# Lower Thames Crossing

## 5.4.4.11 Draft Agreed Statement of Common Ground between (1) National Highways and (2) Transport for London (Tracked changes version)

Planning Inspectorate Scheme Ref: TR010032  
Application Document Ref: TR010032/APP/5.4.4.11

**This is a Draft Agreed Statement of Common Ground with matters outstanding.**

Local Authority:
London Borough of
Havering and Brentwood
Borough Council

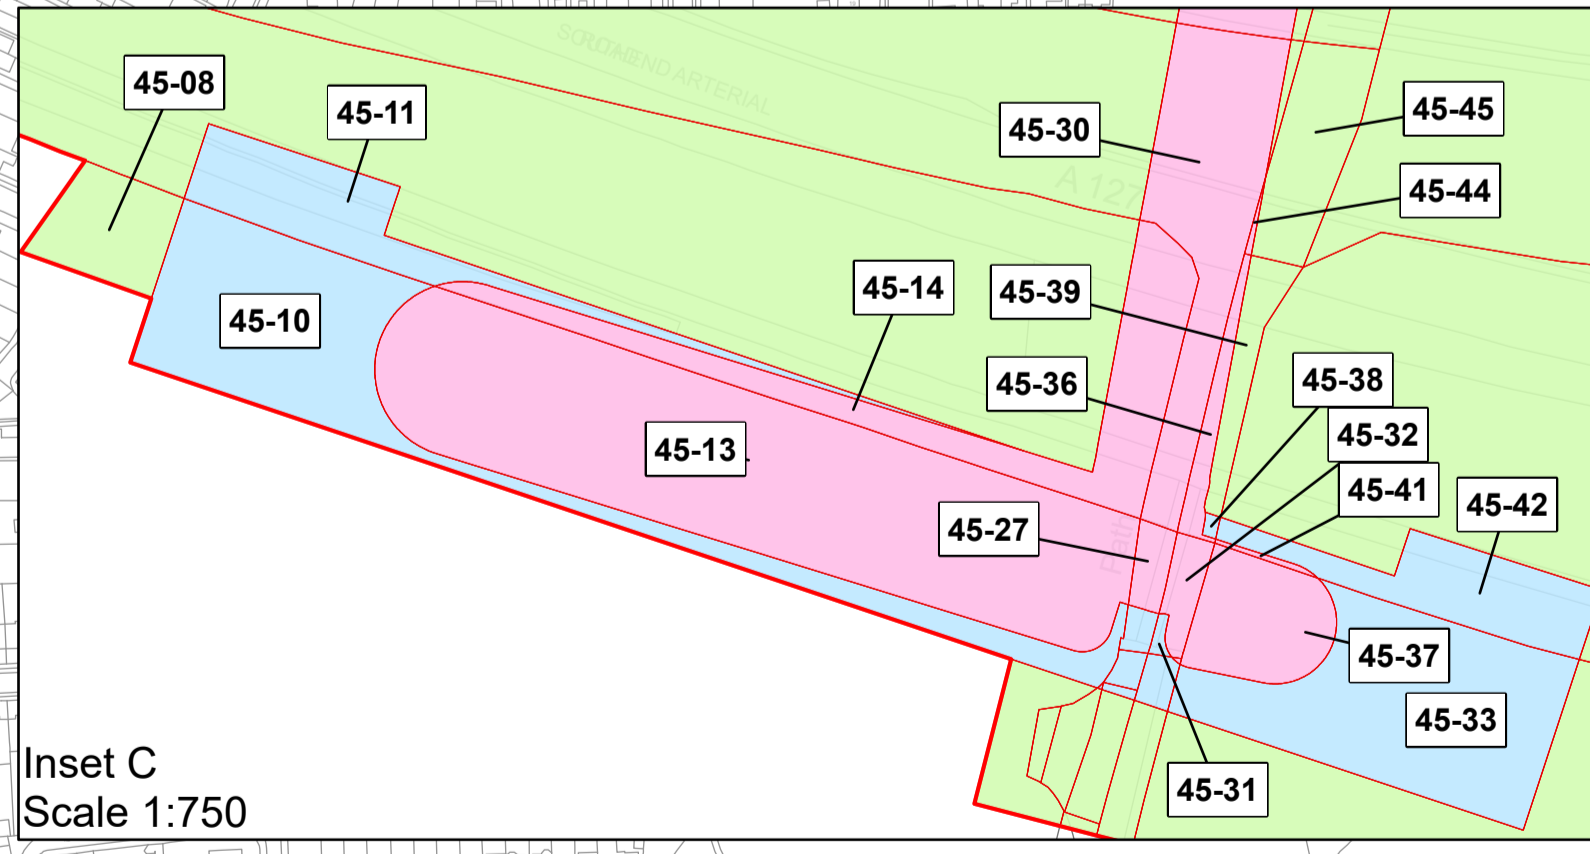
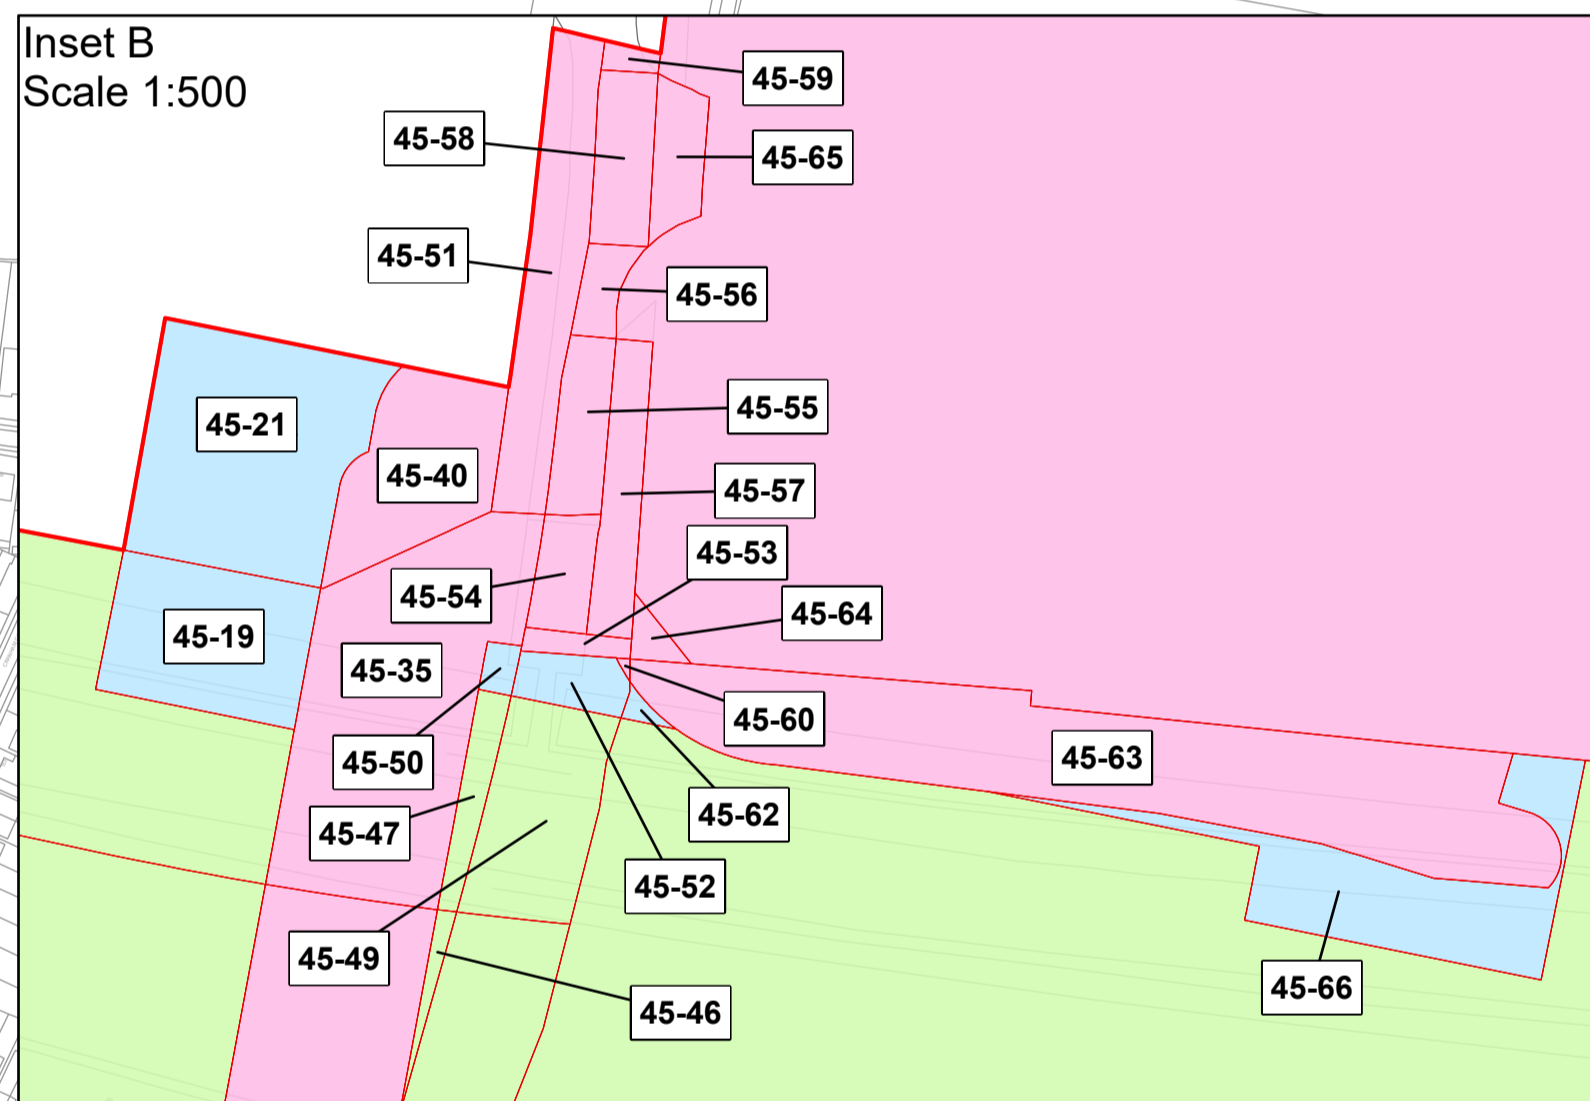
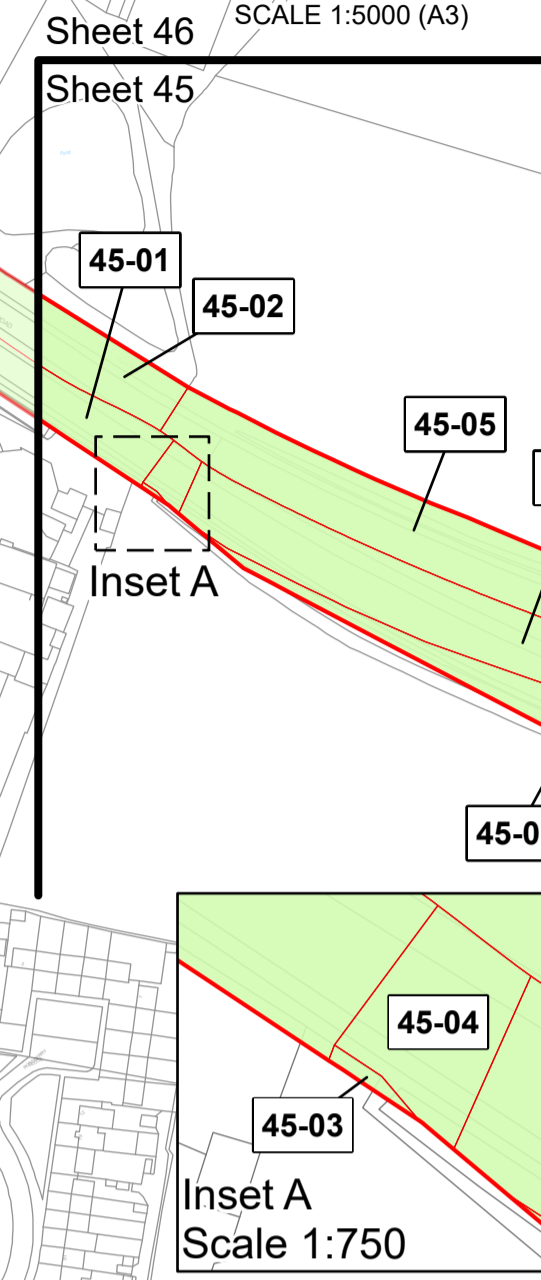
Topic	Item No.	Transport for London Comment	The Applicant's Response	Application Document Reference	Status
Land acquisition  Permanent vs temporary acquisition	2.1.7  RRE	<p>Transport for London owns the freehold of certain parcels of land within the DCO application boundary around J29 of the M25 and relating to the A127.</p> <p>The Land Plans from the previous application documents shared with Transport for London (October 2020) showed most of the land west of the roundabout within the order limits and the TLRN as it passes the roundabout as permanent acquisition. This would suggest that National Highways intends to take on responsibility for this part of the A127. However, the draft DCO that was submitted shows that National Highways are not intending to reclassify any part of the main carriageway of the A127. Permanent acquisition is therefore not required and the powers sought should be for temporary possession only at most but even those powers should be limited.</p> <p>Where the Applicant considers it needs to acquire Transport for London highway land or rights over such land to deliver the Project, Transport for London requires that such land over which Transport for London will</p>	<p>The land use to the west of junction 29 has been amended to address these concerns and the majority of Transport for London's titles are now temporary use. There remain some areas where the Project requires temporary possession of land with the permanent acquisition of new rights for the diversion of utilities. Permanent acquisition of land is also required for a small section of route alignment and for the construction of the new walking, cycling and horse riding (WCH) bridge structure to the west of junction 29. It is agreed that the Applicant and Transport for London will progress discussions to return any permanently acquired land to Transport for London post construction, including the proposed WCH structure which Transport for London shall be responsible for maintaining.</p> <p>These issues were discussed at a meeting on 17 December 2021 (with subsequent communications between the Applicant and Transport for London Land &amp; Property specialists) and the requirements for permanent acquisition of rights were explained and accepted. At the 2022 Local Refinement Consultation, Transport for London reported that the latest acquisition plans provided by the Applicant address many of the concerns previously raised.</p> <p>Details of the land required for the WCH bridge were discussed at a meeting on 20 March 2023 with land and property specialists and legal</p>	<a href="#">Sheets 45 &amp; 46 of the Land Plans [REP1-011]</a>	Matter Under Discussion

Topic	Item No.	Transport for London Comment	The Applicant's Response	Application Document Reference	Status
		<p>remain highway authority should be returned to Transport for London's ownership at no cost following completion of the works. Transport for London raised this matter in its relevant representation where it requested an amendment to the draft DCO, for this provision, but following discussions is now willing to consider its requirements on these matters being included in a side agreement with the Applicant.</p> <p><u>Transport for London understands that the Applicant will be submitting draft protective provisions for the protection of local highway authorities at Deadline 4 which may cover transfer of land. Transport for London will update its position on this issue following review of these protective provisions.</u></p>	<p>representatives from Transport for London and the Applicant present. A draft side agreement between the Applicant and Transport for London is currently being discussed which will include details of the mechanism for transfer of land between the Applicant and Transport for London and the land requirements. <u>As noted by TfL, the Parties are in discussion in relation to the proposed side agreement in an attempt to address issues raised by TfL.</u></p> <p><u>At a meeting on 12 September 2023, further discussions were held including an update on the land required for the bridge and its maintenance, the proposed side agreement between the two parties, powers for utility maintenance and, as TfL notes, draft protective provisions proposed for Deadline 4.</u></p> <p>It is agreed that the above-mentioned discussions on the final ownership and potential return of acquired land will occur post-DCO consent.</p>
